An
Bord
Pleanála

Board Direction
BD-016486-24
ABP-317121-23

apparatus. The information contained herein does not purport

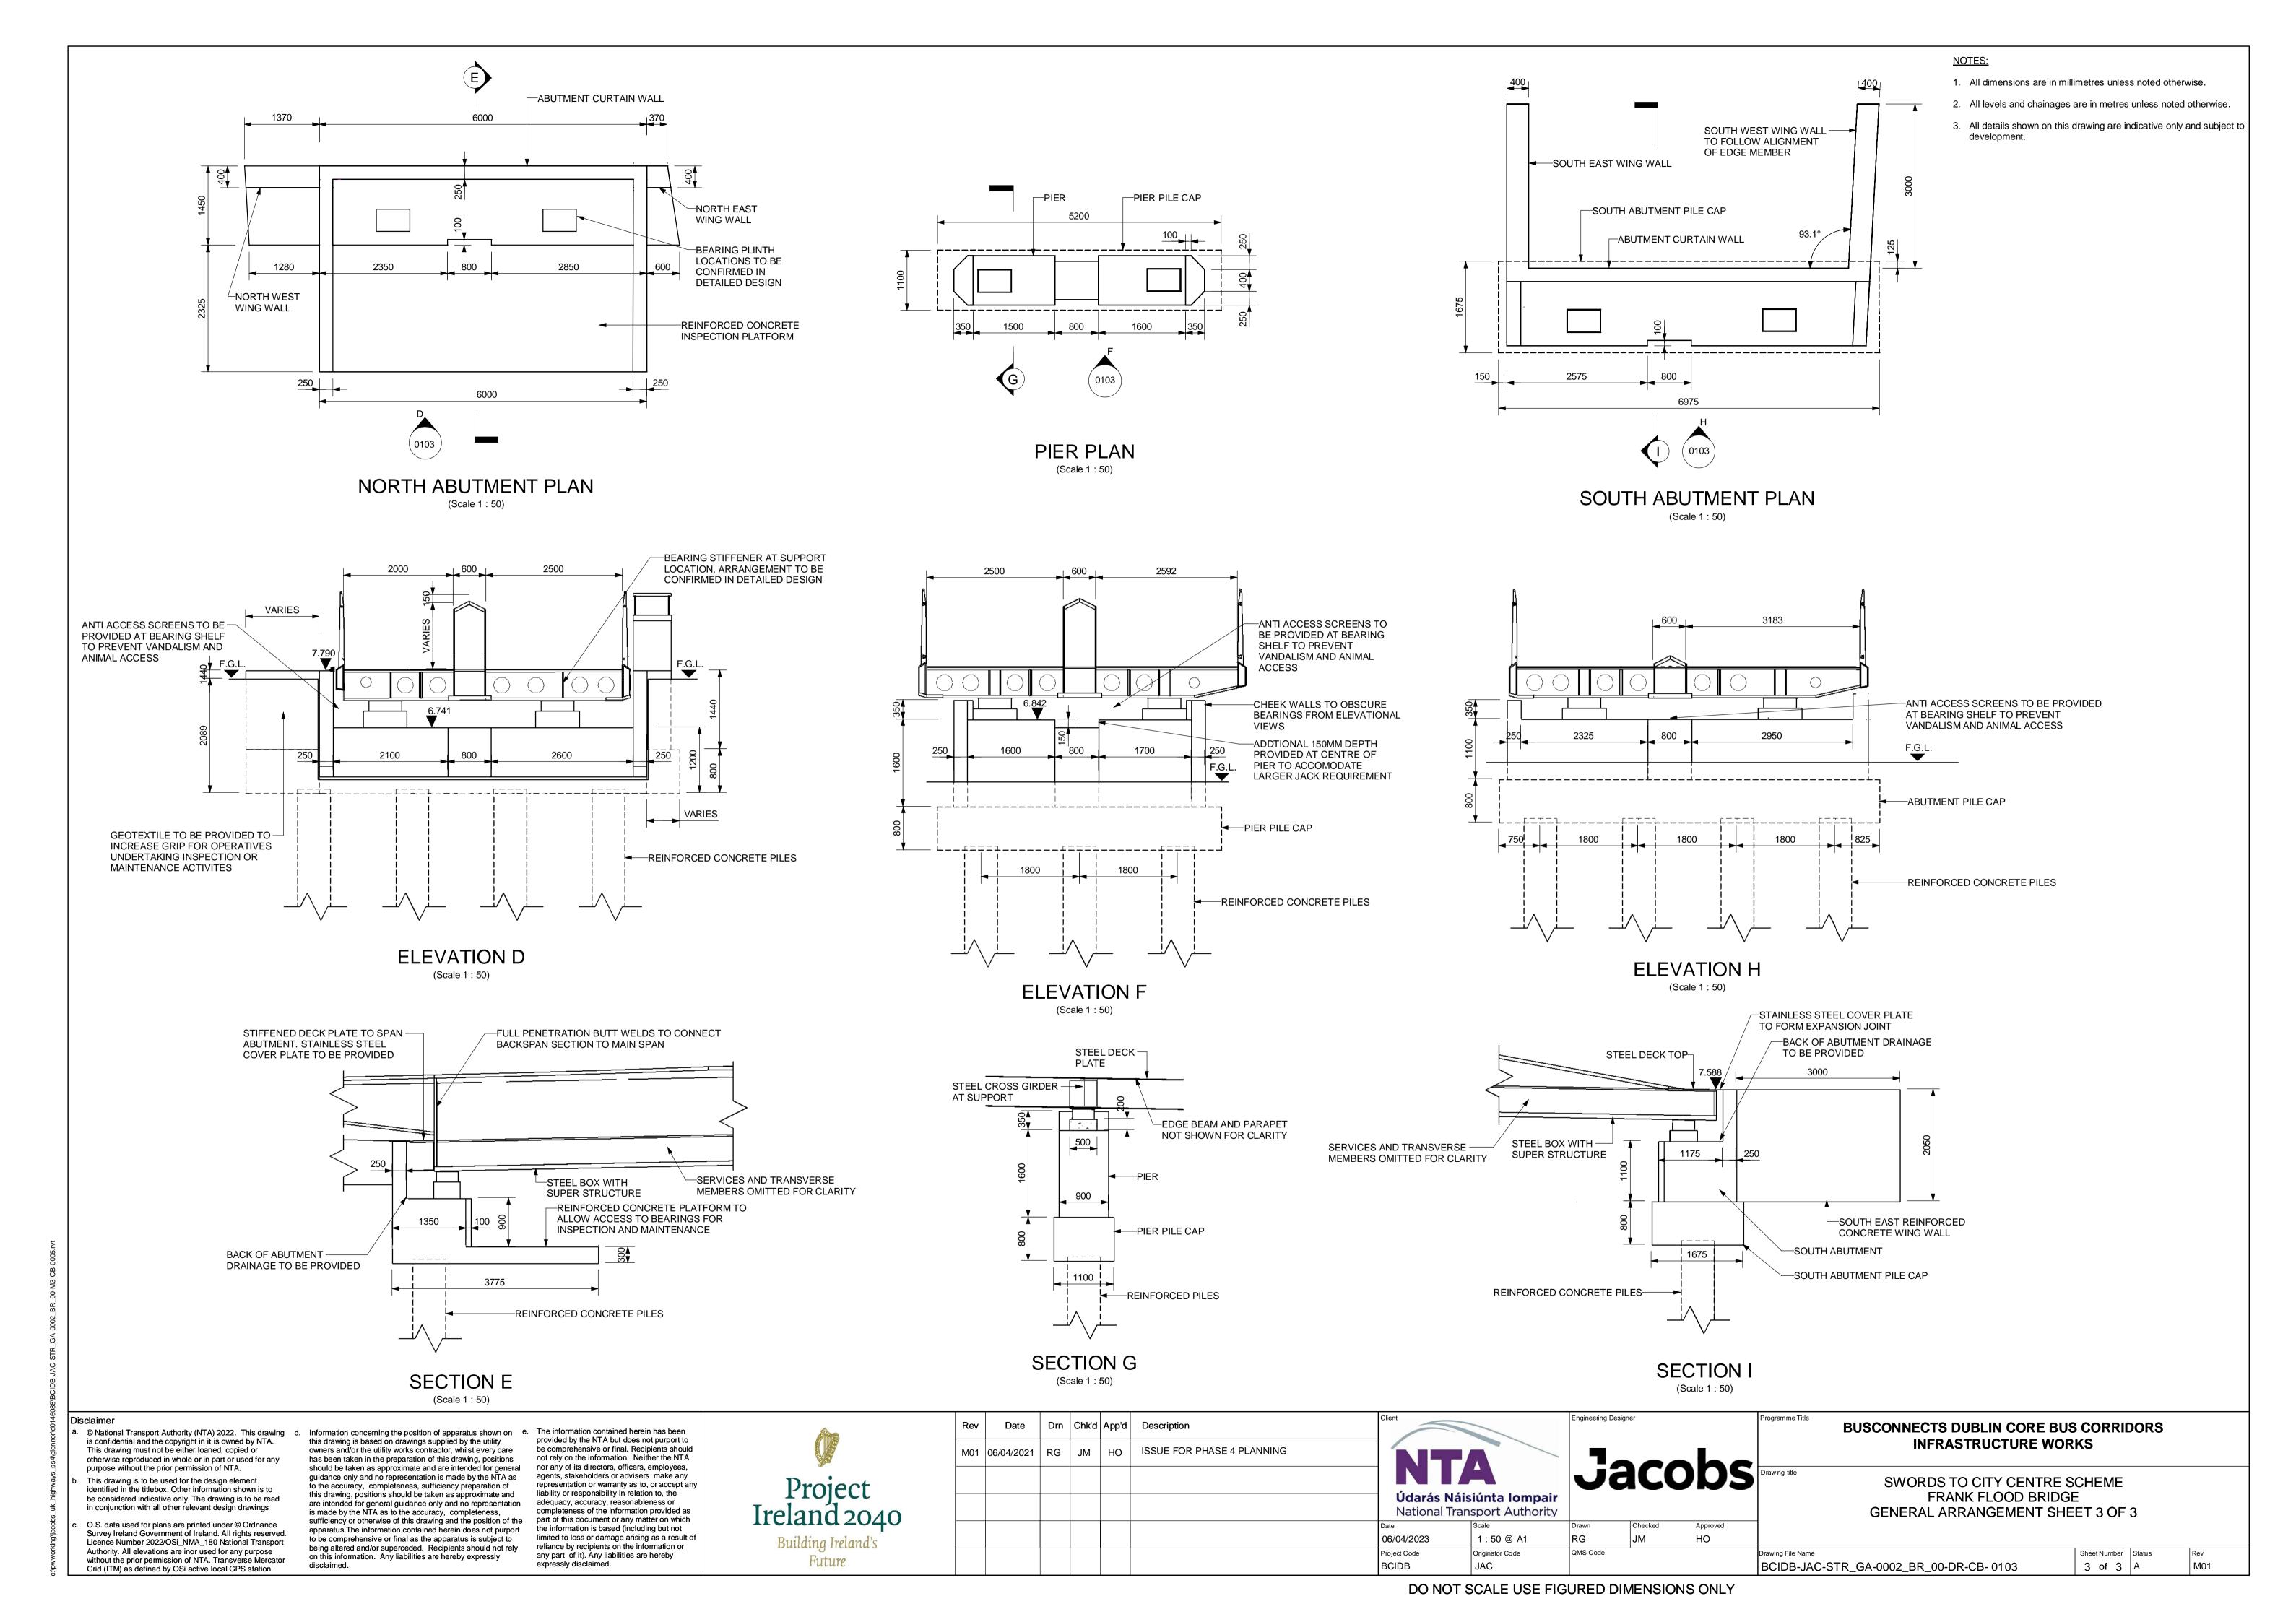
6. Prior to commencement of development, the developer shall agree in writing with Dublin City Council the details of the type of finishes/materials for the proposed pedestrian/cycle bridge adjacent to Frank Flood Bridge.
